AENC-NG-CNS-REP-0208

Norwich to Tilbury

Document: 8.1 Errata List

Planning Inspectorate Reference: EN020027

Figure 7.5 - Air Quality -  
Affected Road Network  
Page 1 of 13

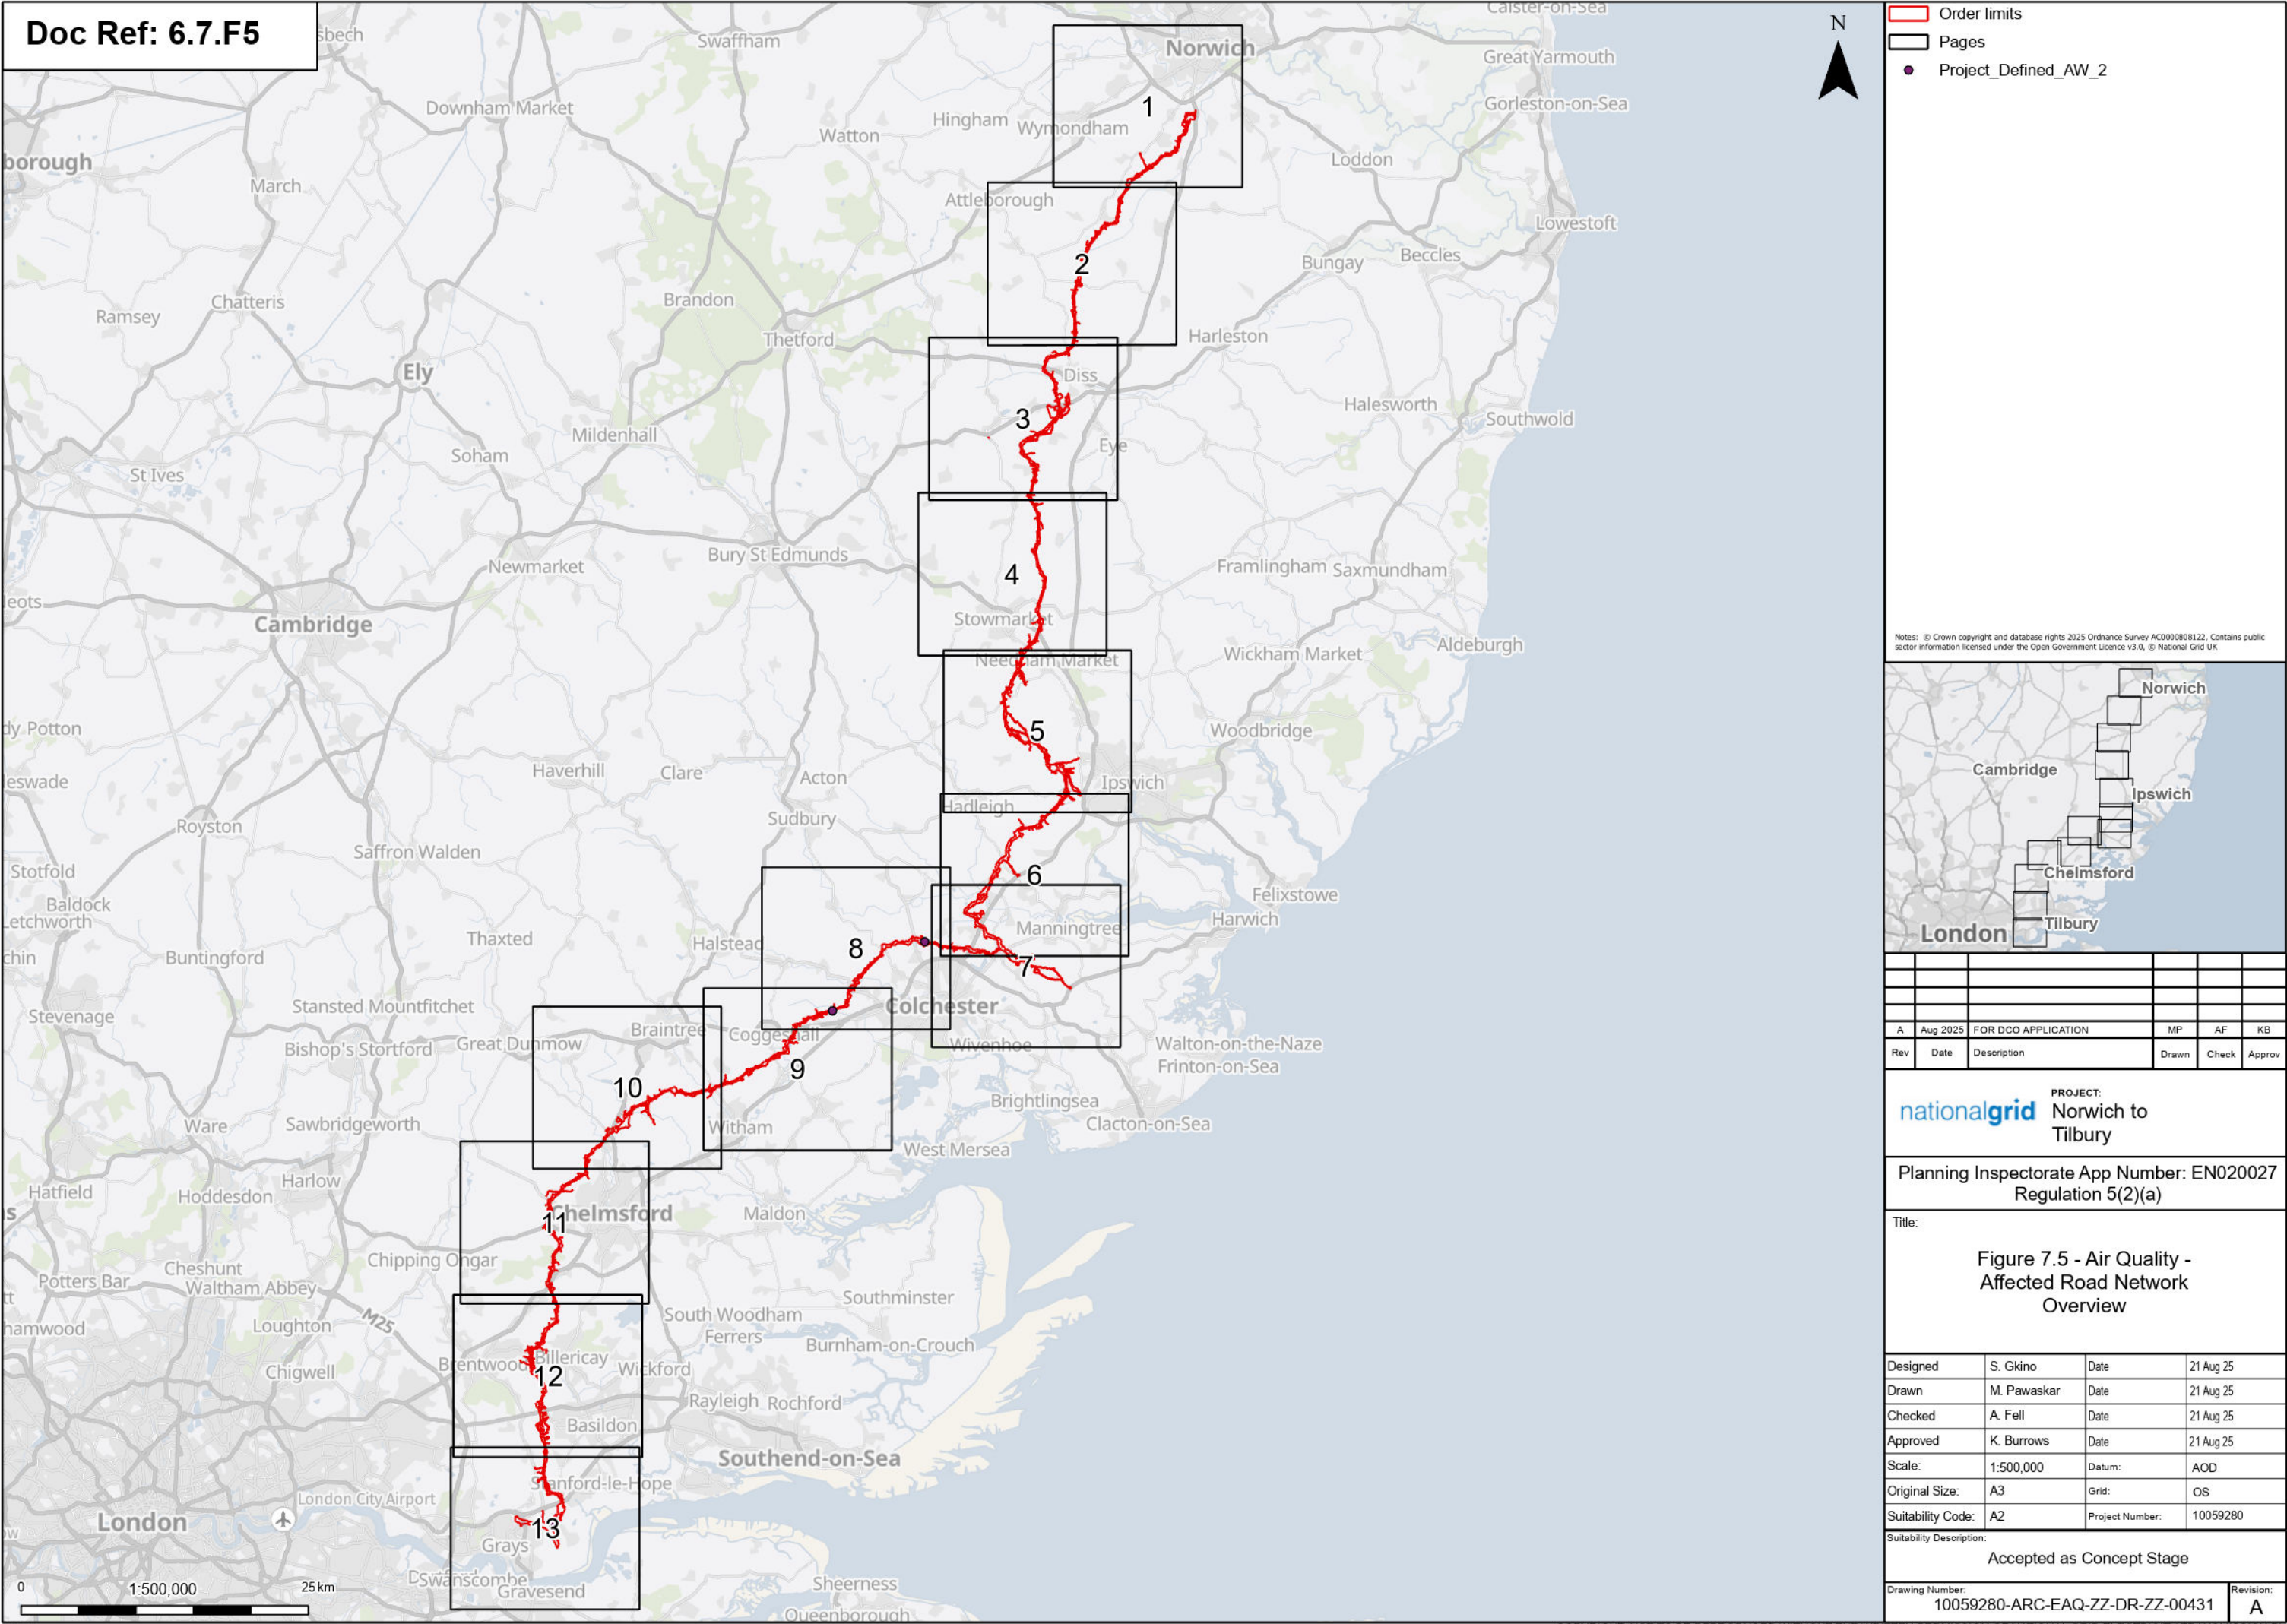
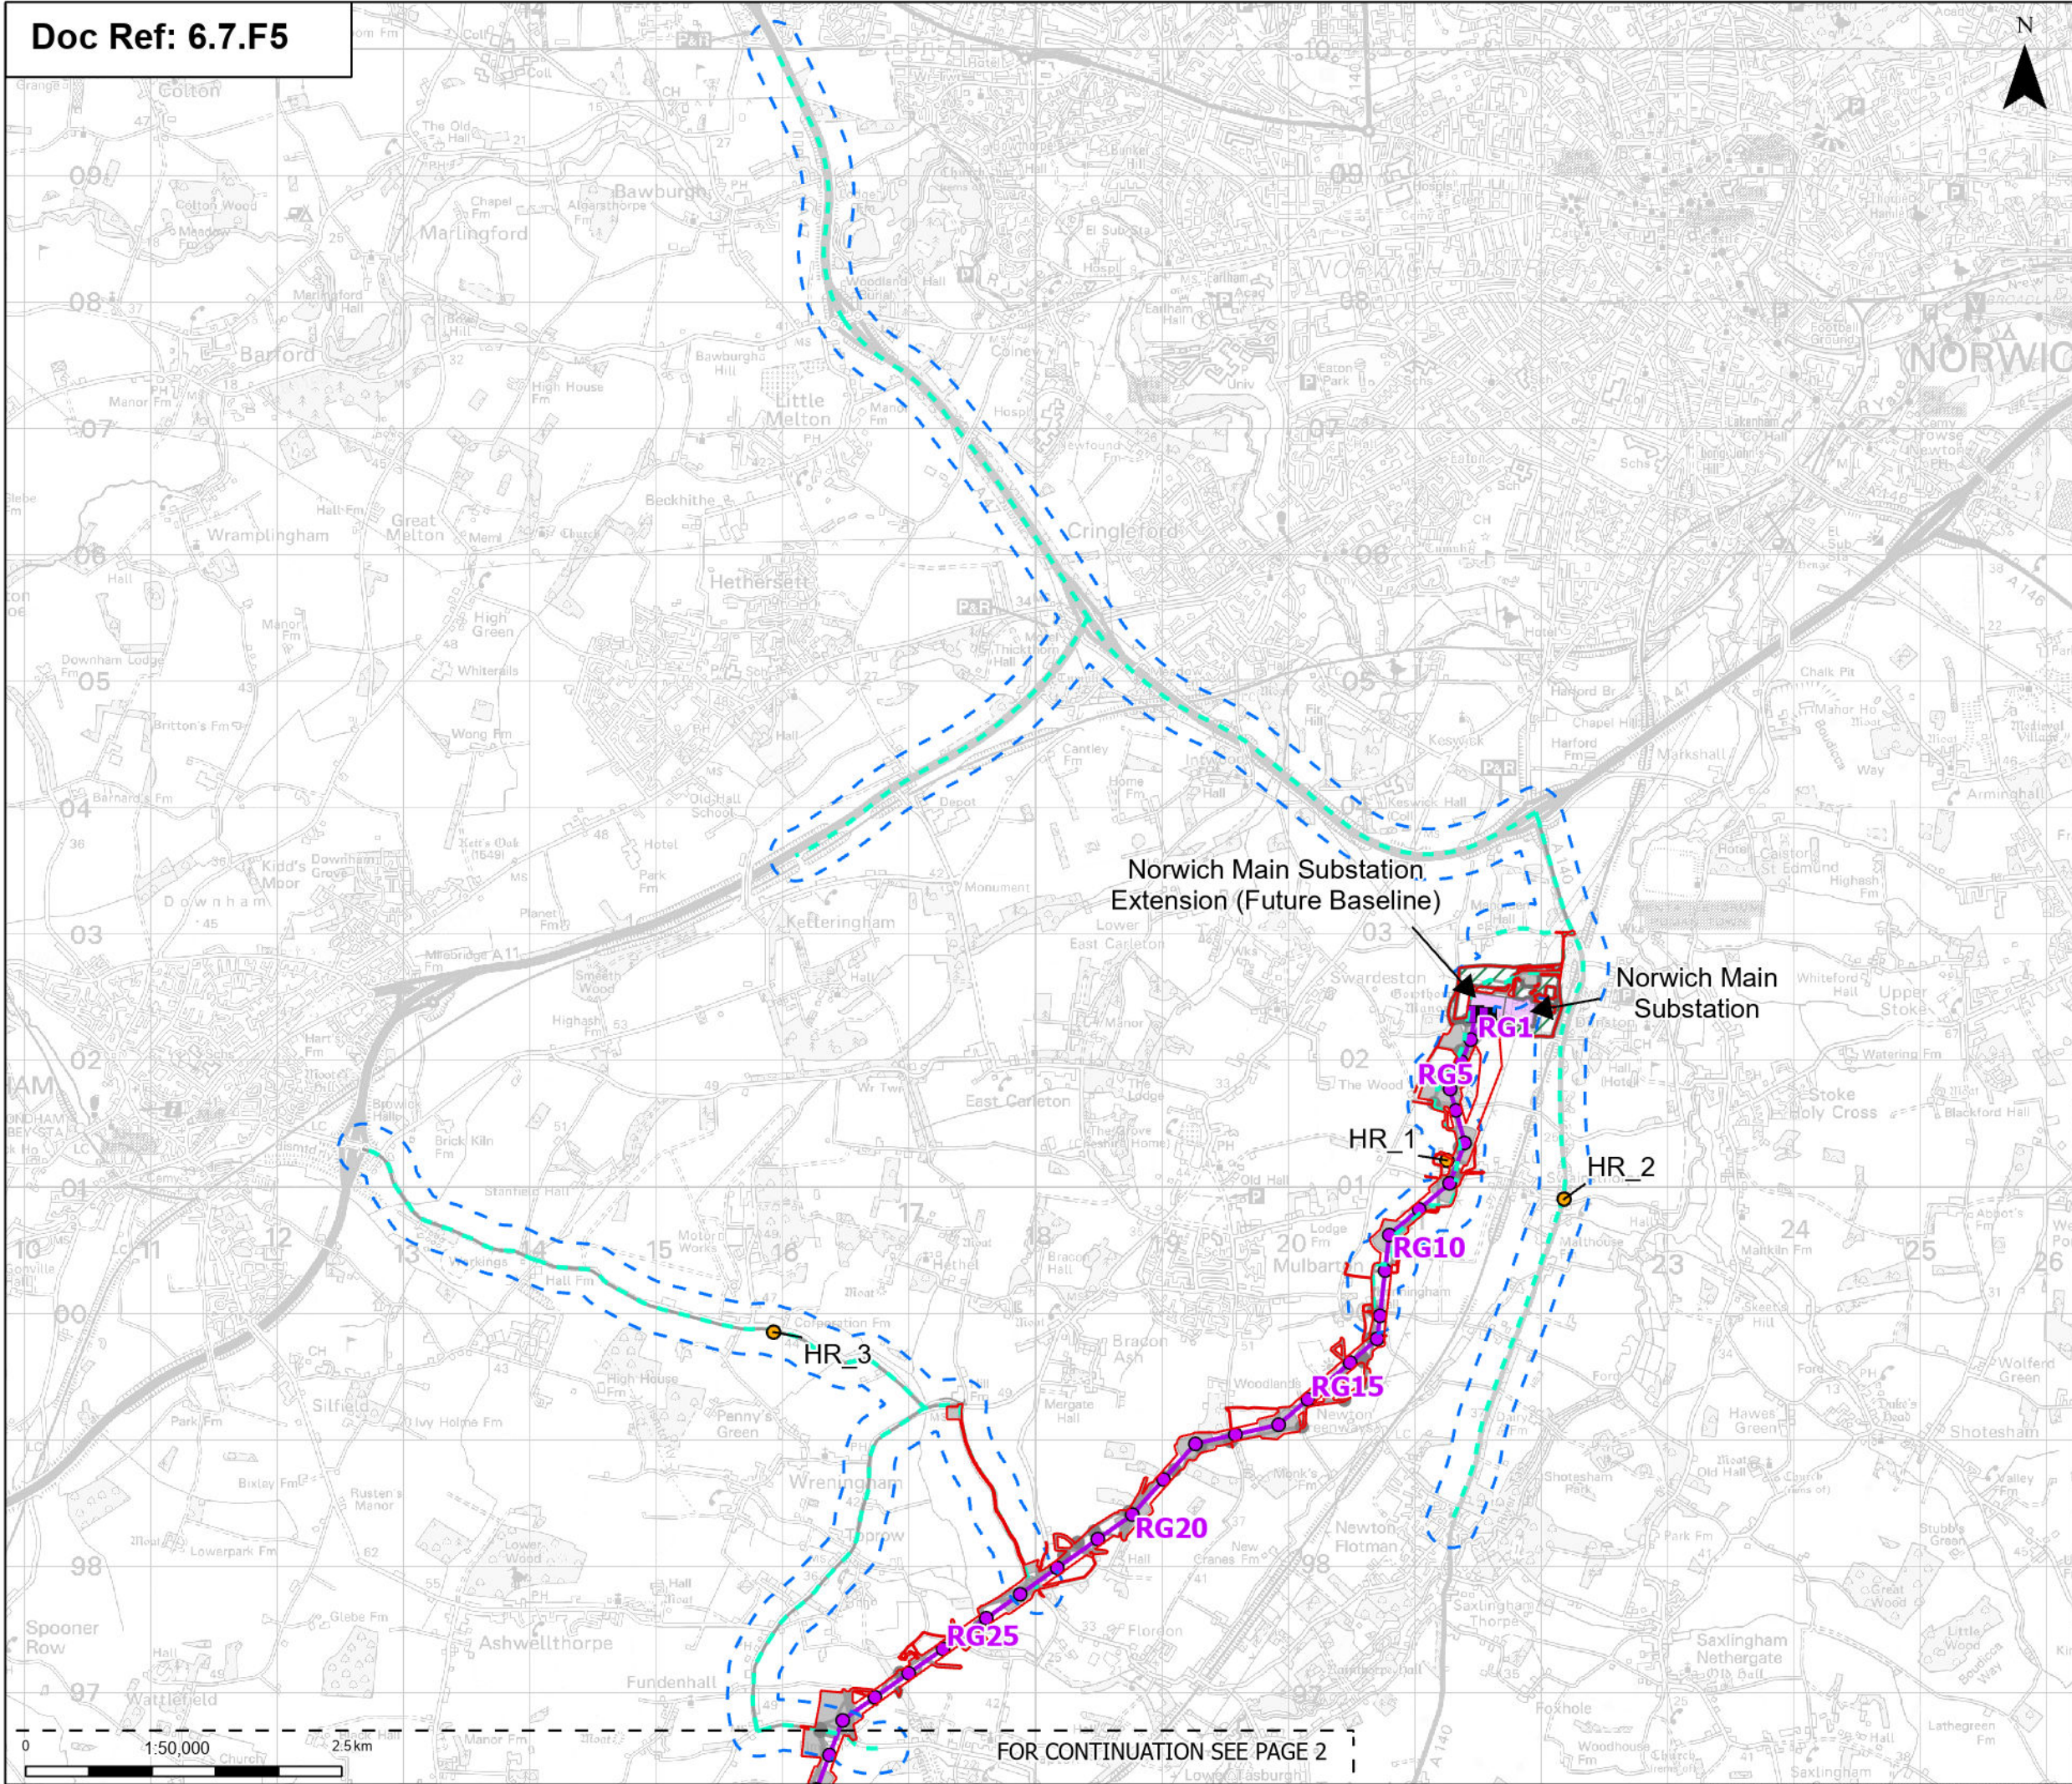
6.7.F5	Environmental Statement Figure 7.5: Air Quality – Affected Road Network	N/A	Duplicated dataset layer included within Figure.	Dataset ‘Project_Defined_AW_2’ is presented in error within the Figure. All data is included within the ‘Ecological receptors’ dataset. Therefore, the ‘Project_Defined_AW_2’ dataset should be ignored and ‘Ecological receptor’ dataset should be relied upon.
